**RE: REVISED ENGINEER CERTIFICATION FOR OFFICE WAREHOUSE  
FACILITY (C17-D2A14) CERTIFICATION STATEMENT DATED 11/8/96  
AND ENGINEER'S STAMP DATED 11/22/96.**

**RE: ENGINEER CERTIFICATION FOR OFFICE WAREHOUSE FACILITY  
(C17-D2A14) CERTIFICATION STATEMENT DATED 11/8/96.**

**RE: GRADING AND DRAINAGE PLAN FOR OFFICE WAREHOUSE  
FACILITY, LOTS 10 & 11, RICHFIELD PARK, C17/D2A14,  
SUBMITTED FOR BUILDING PERMIT APPROVAL, ENGINEER'S  
STAMP DATED 3/9/95.**

ARCH. SEAL ENGR. SEAL SHEET: C-1

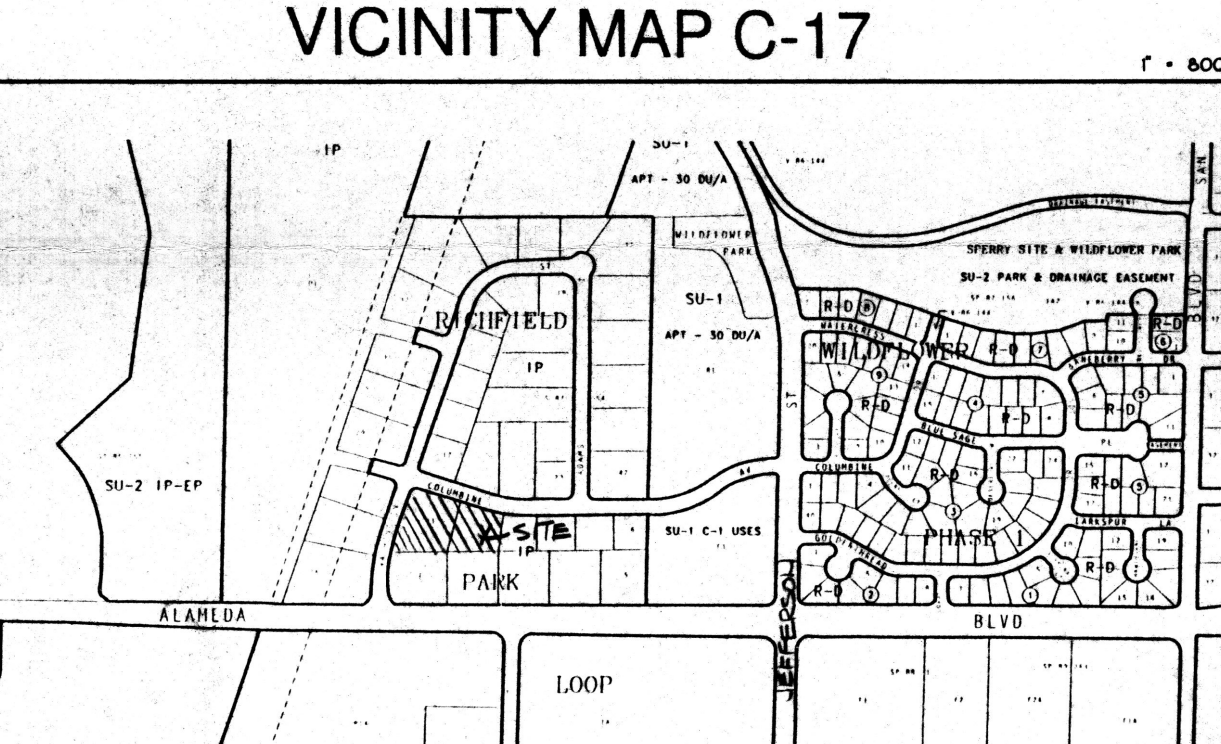
1. As-built designation on your legend.
2. S.O. 19 approval plan or tag for the sidewalk culvert. Re-date you certification and resubmittal.
